SUBJECT: Engineering Review Comment
Mountain View Electric Association Inc. (MVEA)

Project Name: The Estates at Cathedral Pines - PUD/Preliminary Plan
Project Number: PUDSP2210
Description: Proposed development of 8 residential lots located at Winslow Dr.
and south of Saxton Hollow Rd. in Township 12S, Range 66W, Section 02.

SHEET TITLE: PUD DEVELOPMENT PLAN

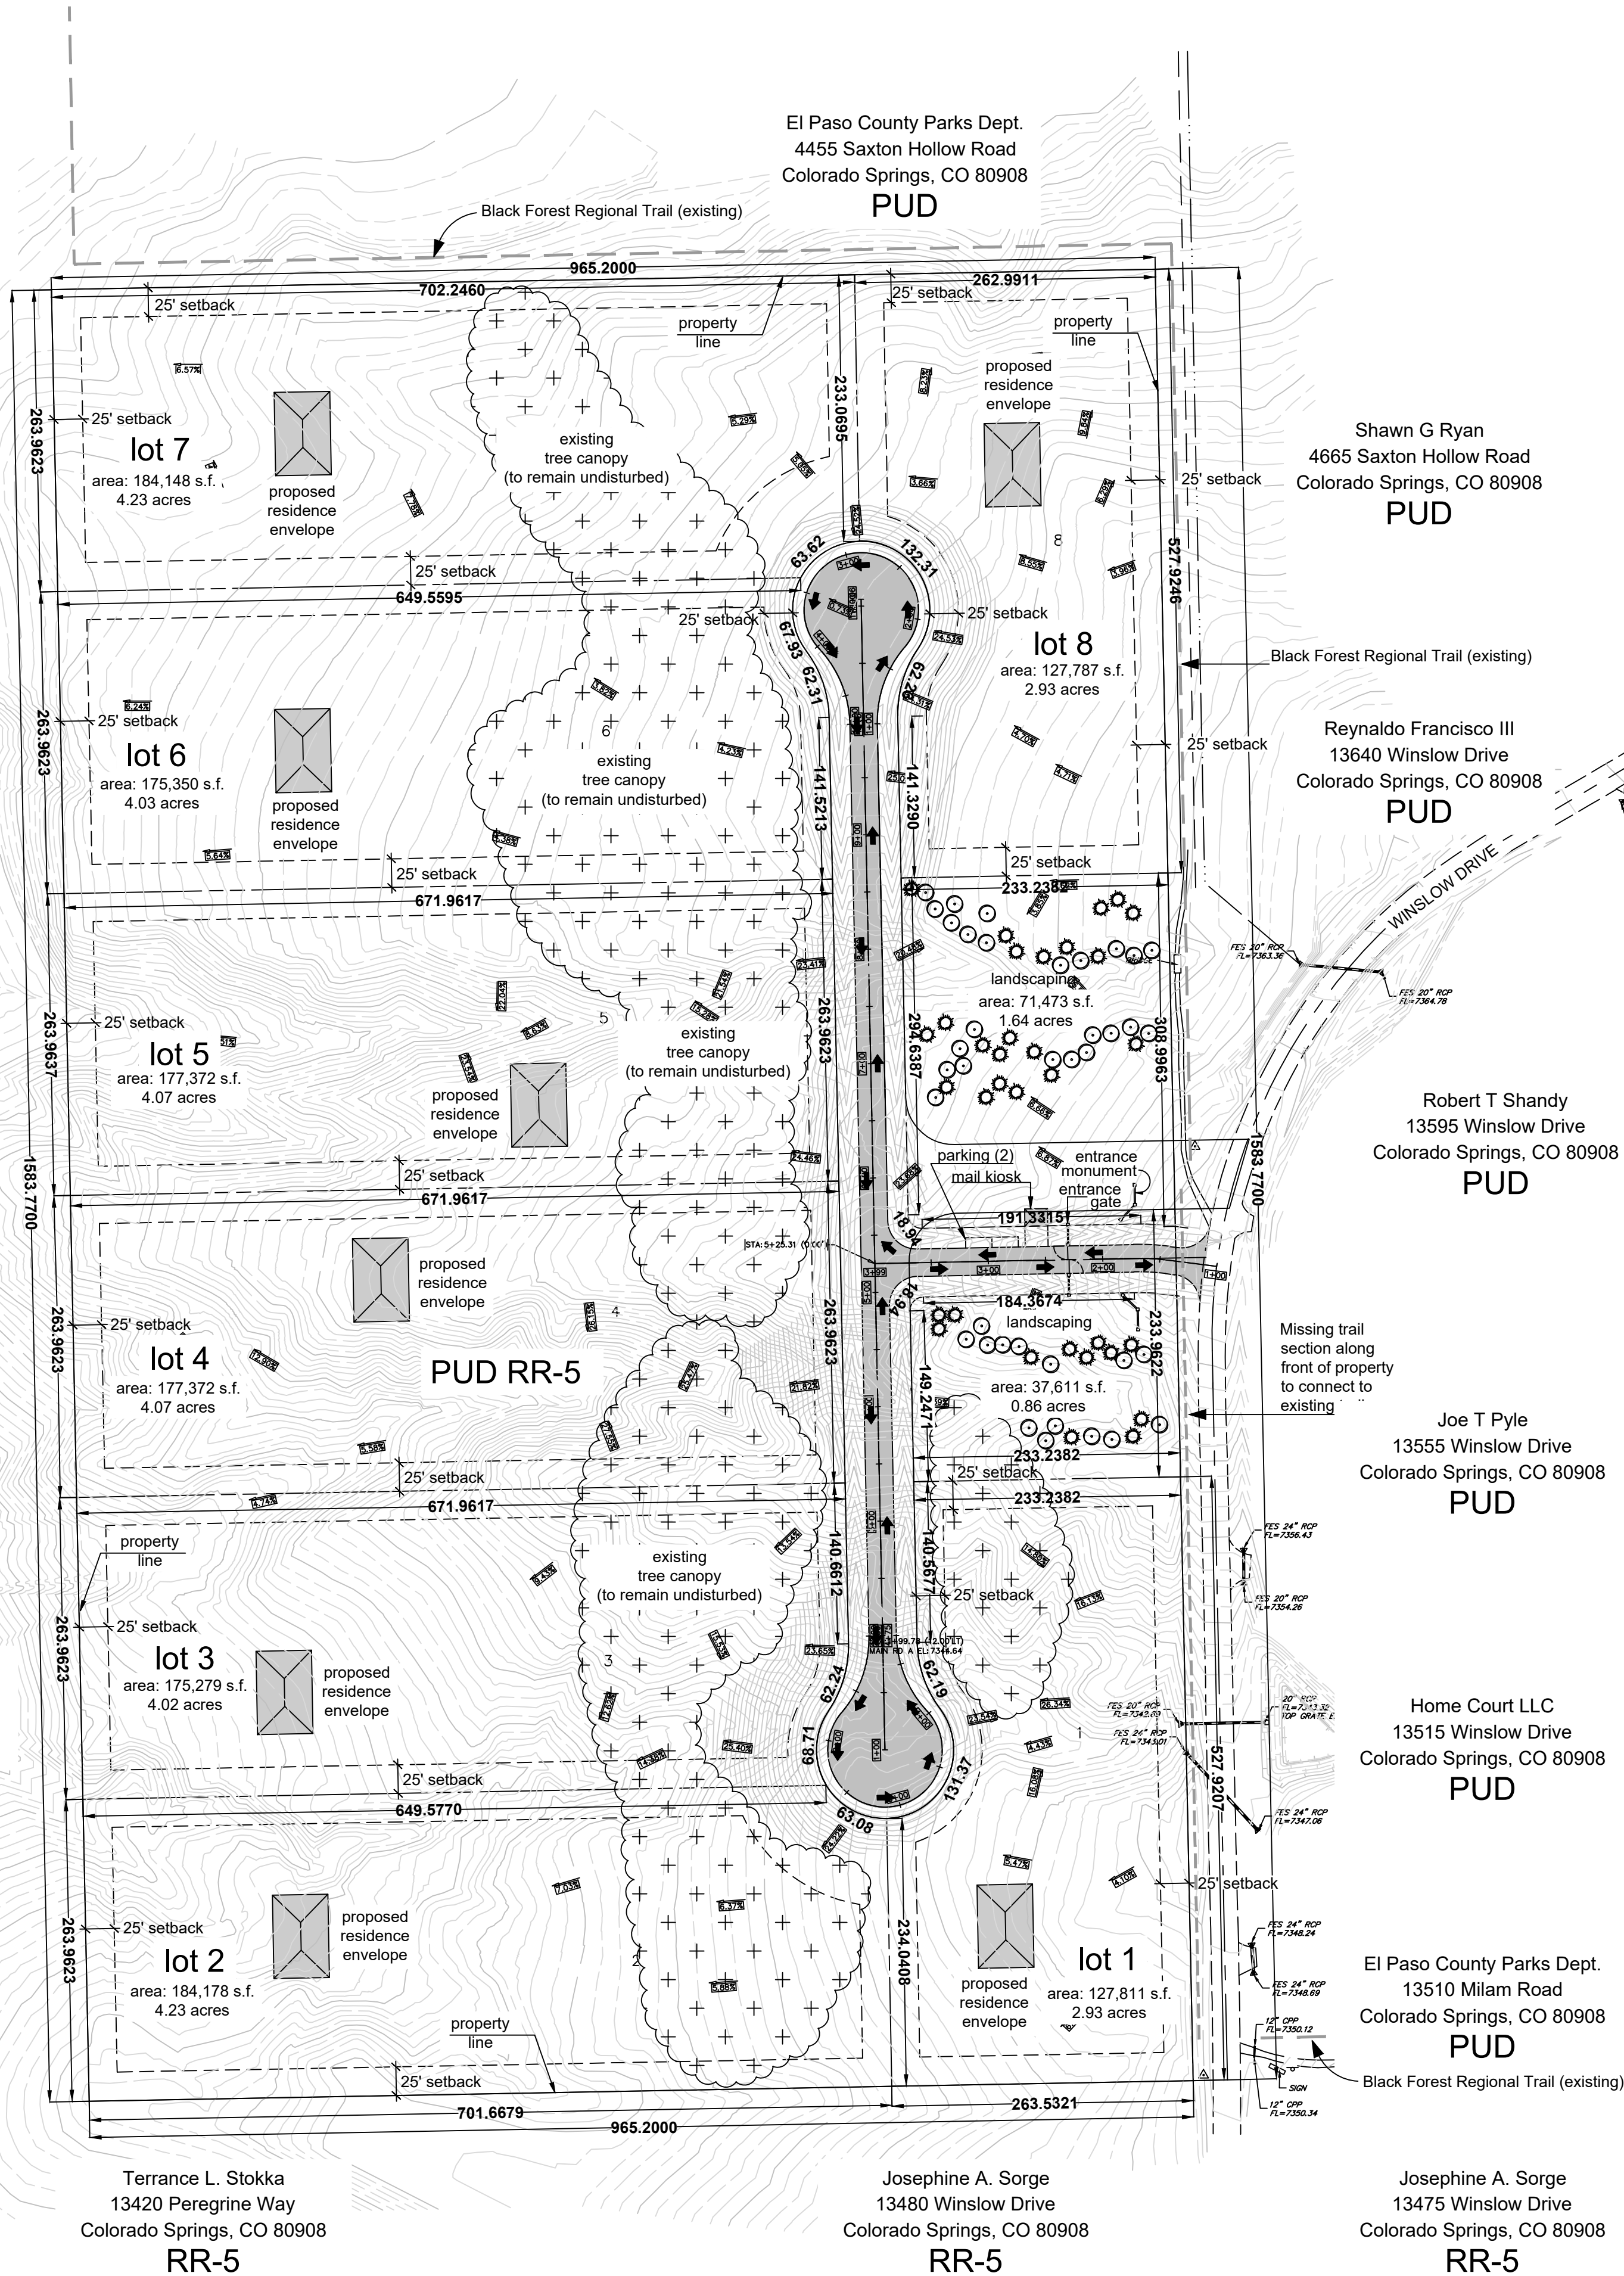
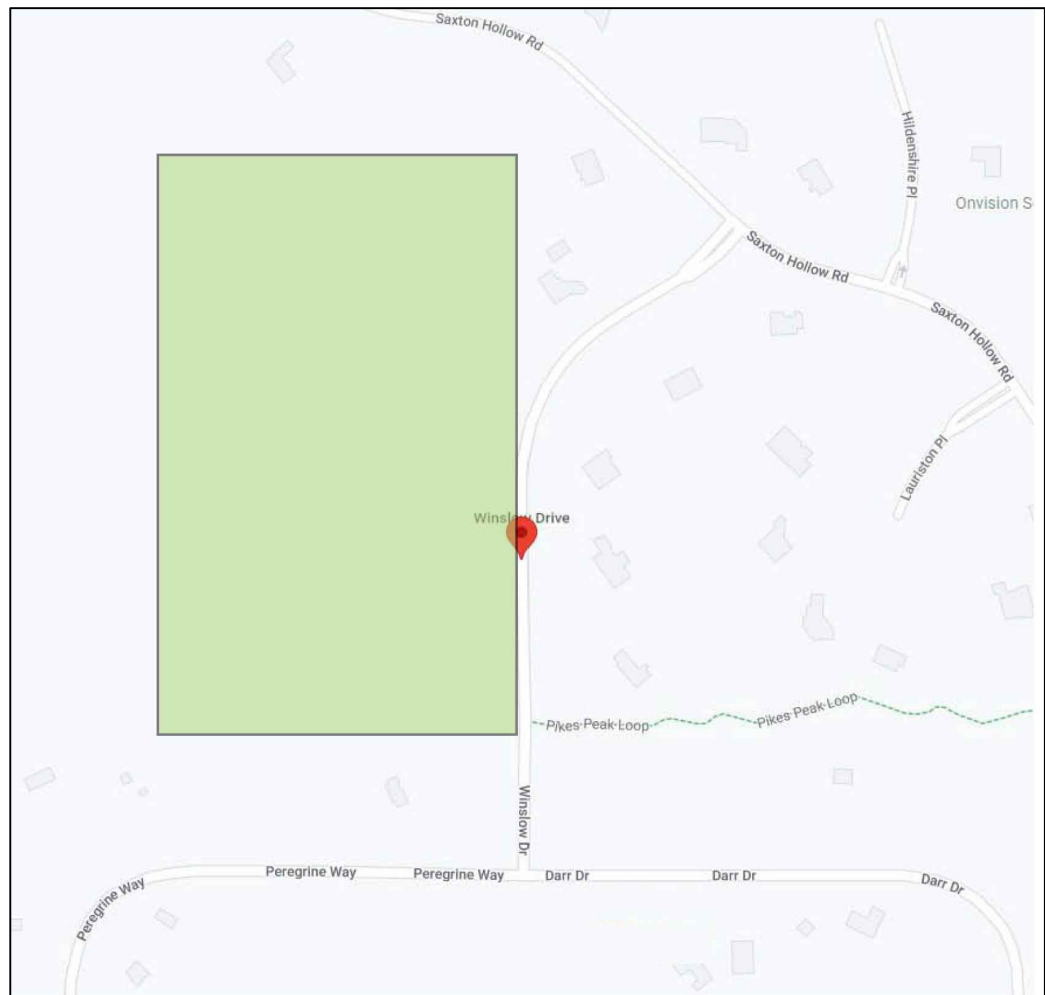
MVEA requests a ten (10) foot front, side, and rear lot utility easements on the plat. MVEA also requests the platting of MVEA's existing facilities with easements on the plat. Additional easements may be required.

MVEA has existing facilities near and within this parcel of land. If there is any damage, removal or relocation of facilities it will be at the expense of the applicant.
